Ribble Valley Borough Council
By email

Your ref 3/2021/0275
Our ref DC/21/1403 v11
Date 23-AUG-24

Location: Land behind The Dog Inn, Market Place, Longridge PR3 3RR
Proposal: Proposed erection of 9 new dwellings and associated works

Planning Application
Plots 7 & 8. Plan

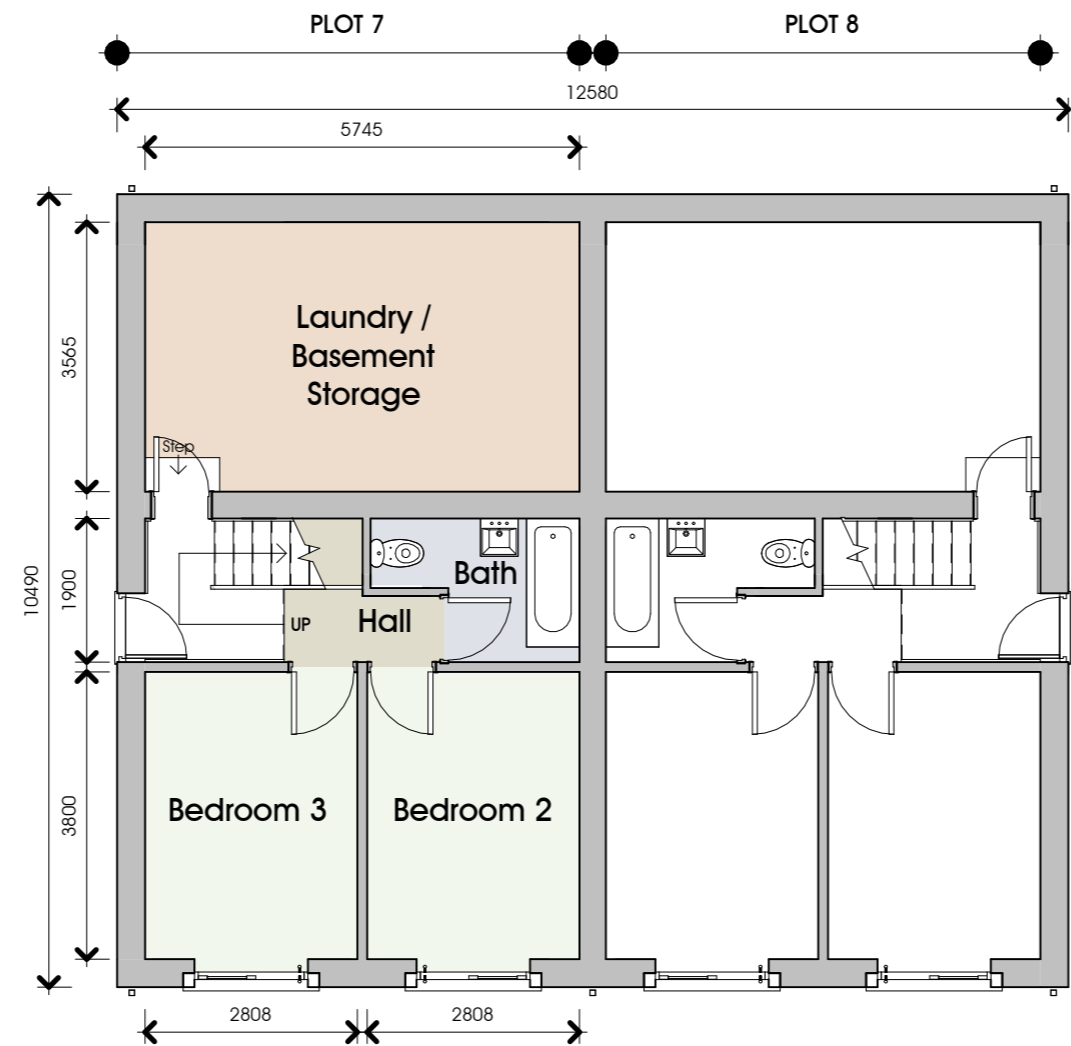
Following our review of the recent submission, the letter from Bob Ford of Reford, dated 3rd July 2024 noted that *'In order to prevent any exceedance flows from United Utilities manhole 6102, it is proposed to extend the boundary wall of Plot 8 along the western elevation to direct any exceedance flows away from Plots 7 and 8 thus ensuring that Plots 7 and 8 will not be at risk of flooding from the manhole.'*

It is not clear what type of boundary wall will be built to prevent any exceedance flow to enter the new properties. **Please submit a cross section drawing of the boundary wall, including the type of material, foundation design and the size of the wall for our assessment.**

Proposed Site Plan
1 : 200
0 1 5 10m

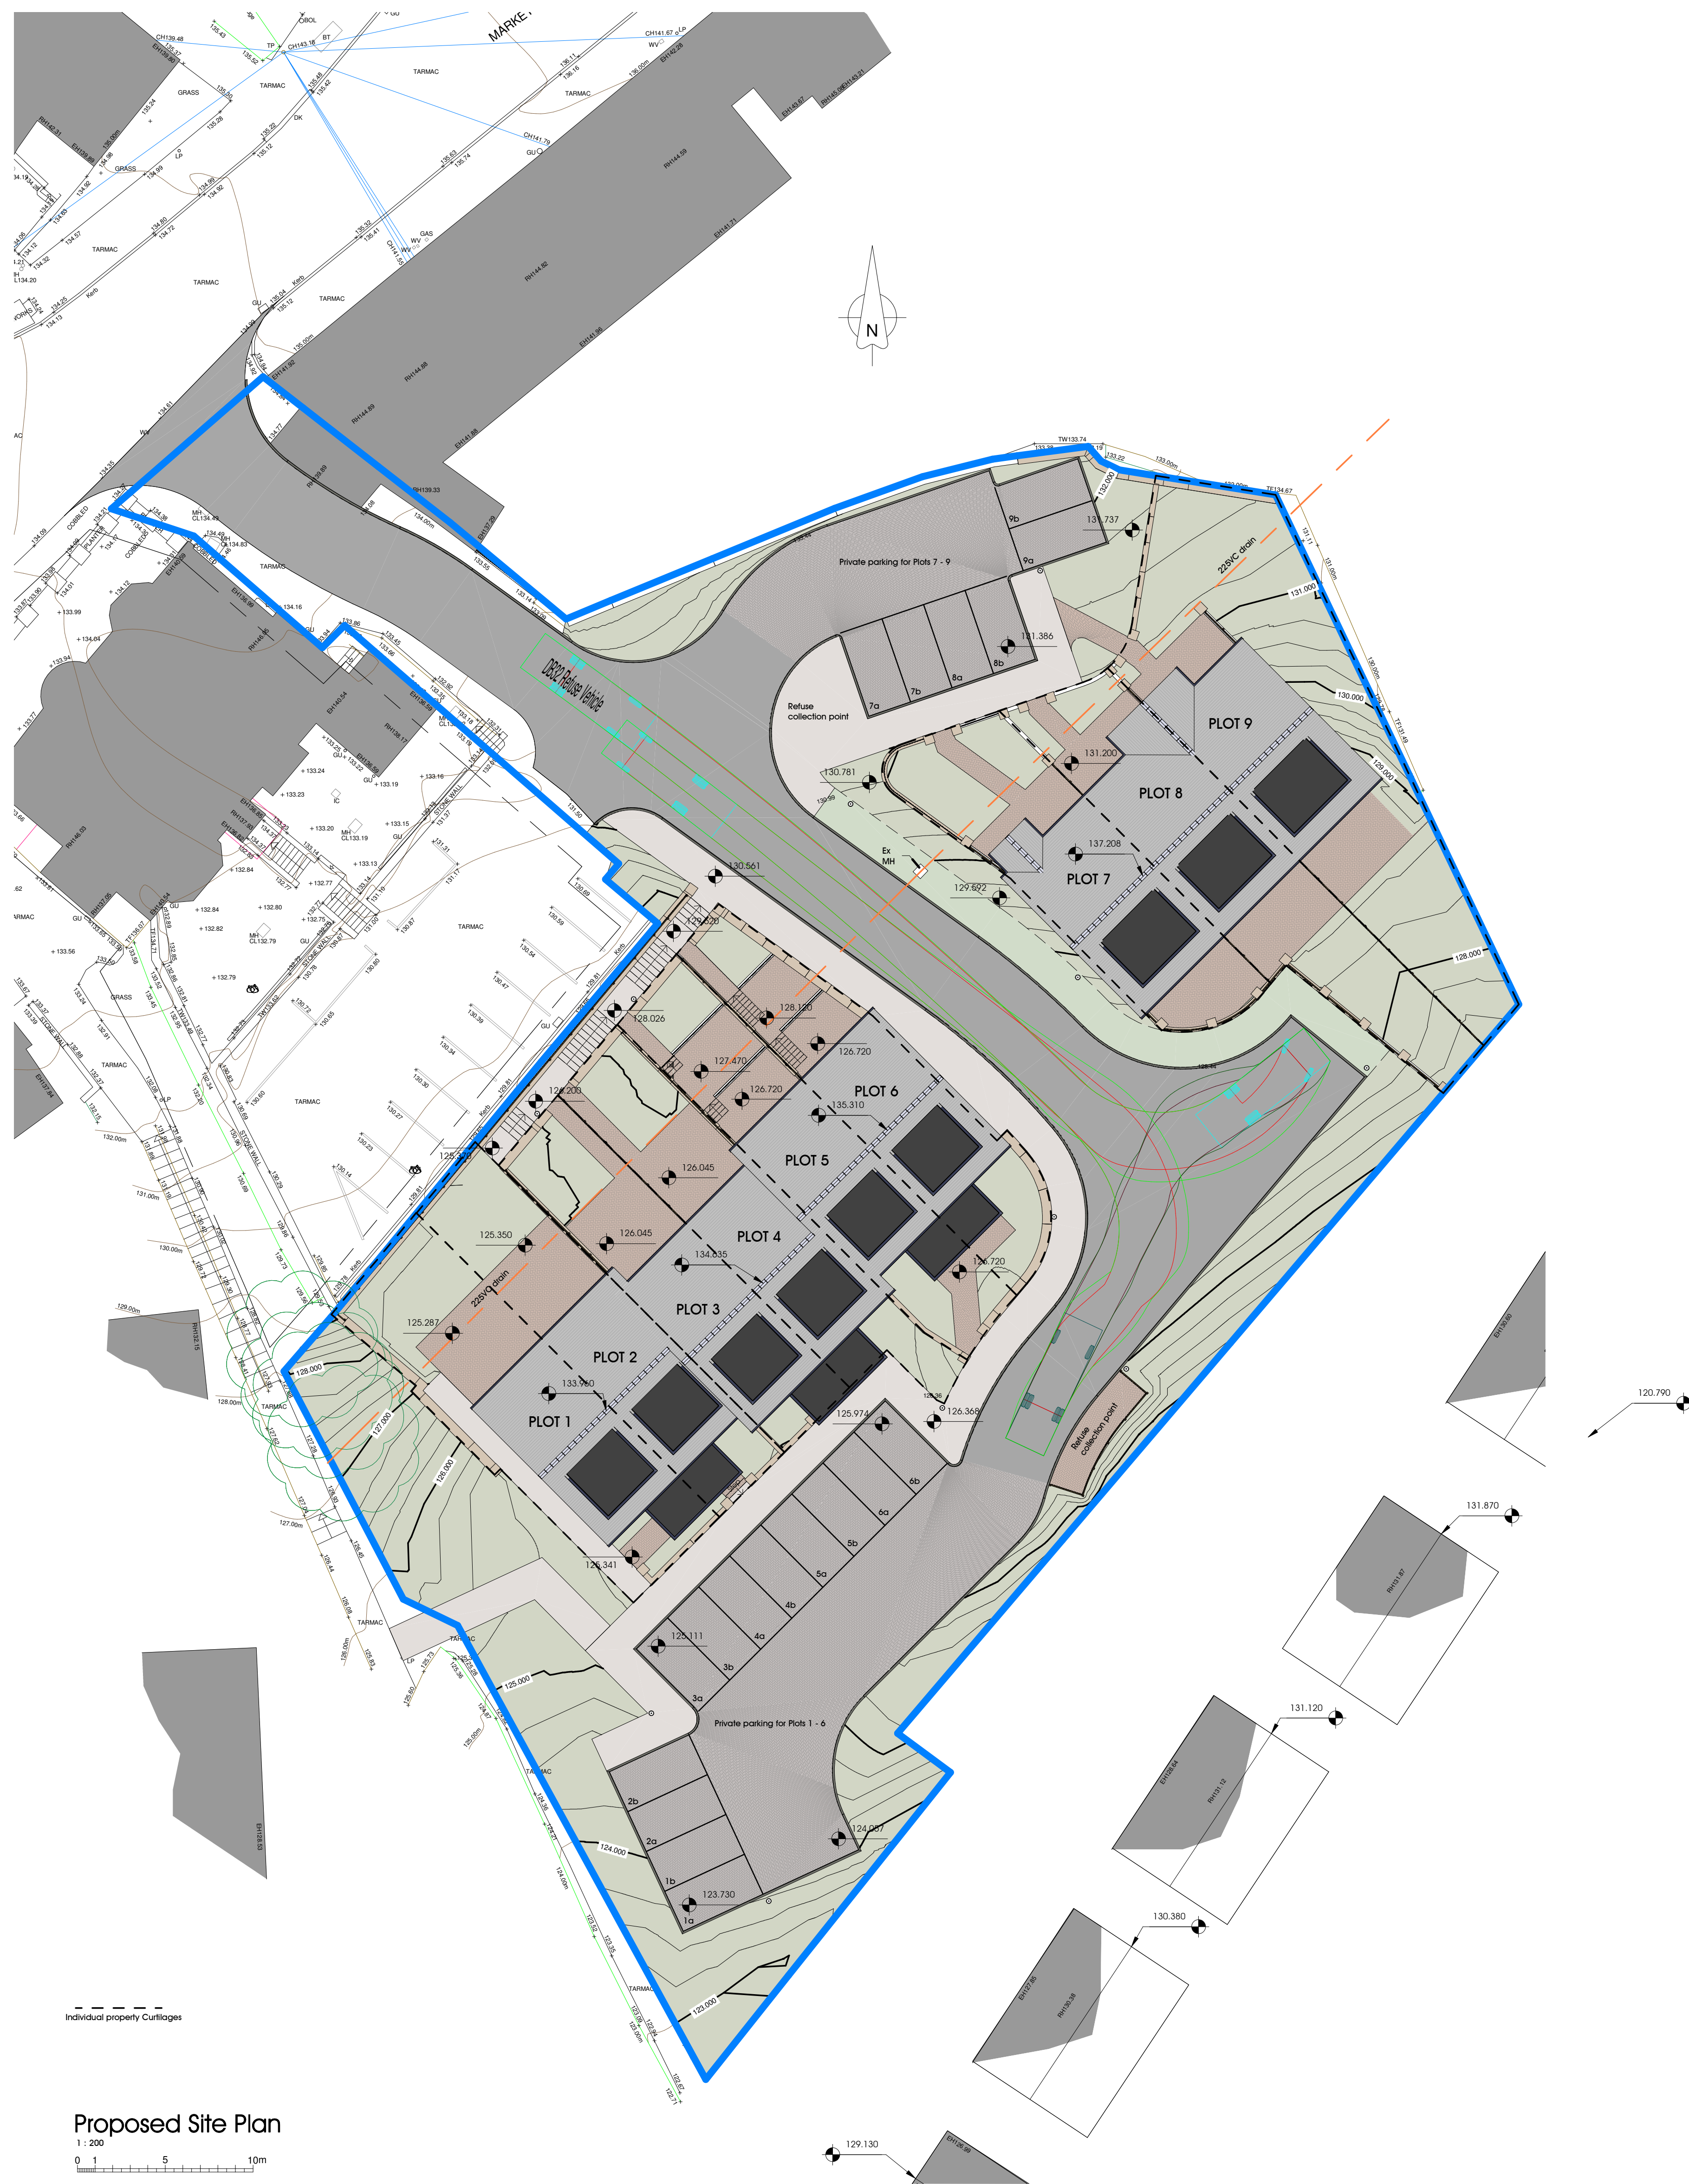
Following our review of the submitted Drainage Strategy, and further to the previous comments we have provided in relation to this application, we note that exceedance flow paths have been shown for the proposed new manhole on the western boundary of the site, however it does not include overland flow paths from the existing manhole MH6102. The cover level for MH6102 is 127.157 AOD however the proposed finished flood levels for Plots 7 and 8 are 126.404 AOD. We request that the applicant confirms the flood exceedance path from this manhole and, if required, includes measures to ensure that Plots 7 and 8 are not at risk of flooding from the existing manhole, including raising finished floor levels and/or mitigation measures/features to ensure the properties are not at risk of flooding. Noting this is a full application, and site levels and finished floor levels are intrinsically linked to the proposed site layout, we request that

updated information is submitted for our review and comment prior to the determination of this application.

A public sewer crosses the site and we may not permit building over it. We require an access strip for maintenance or replacement. The minimum distances that might be acceptable to United Utilities are detailed within Part H of the Building Regulations however, **we recommend the applicant determines the precise location, size, depth and condition of the pipeline as this is likely to influence the required stand-off distance from any structure and could impact upon the proposed site layout.** We would like to draw the applicant’s attention to further information contained in the Appendix to this letter, Section 2.0 ‘United Utilities’ Property, Assets and Infrastructure’.
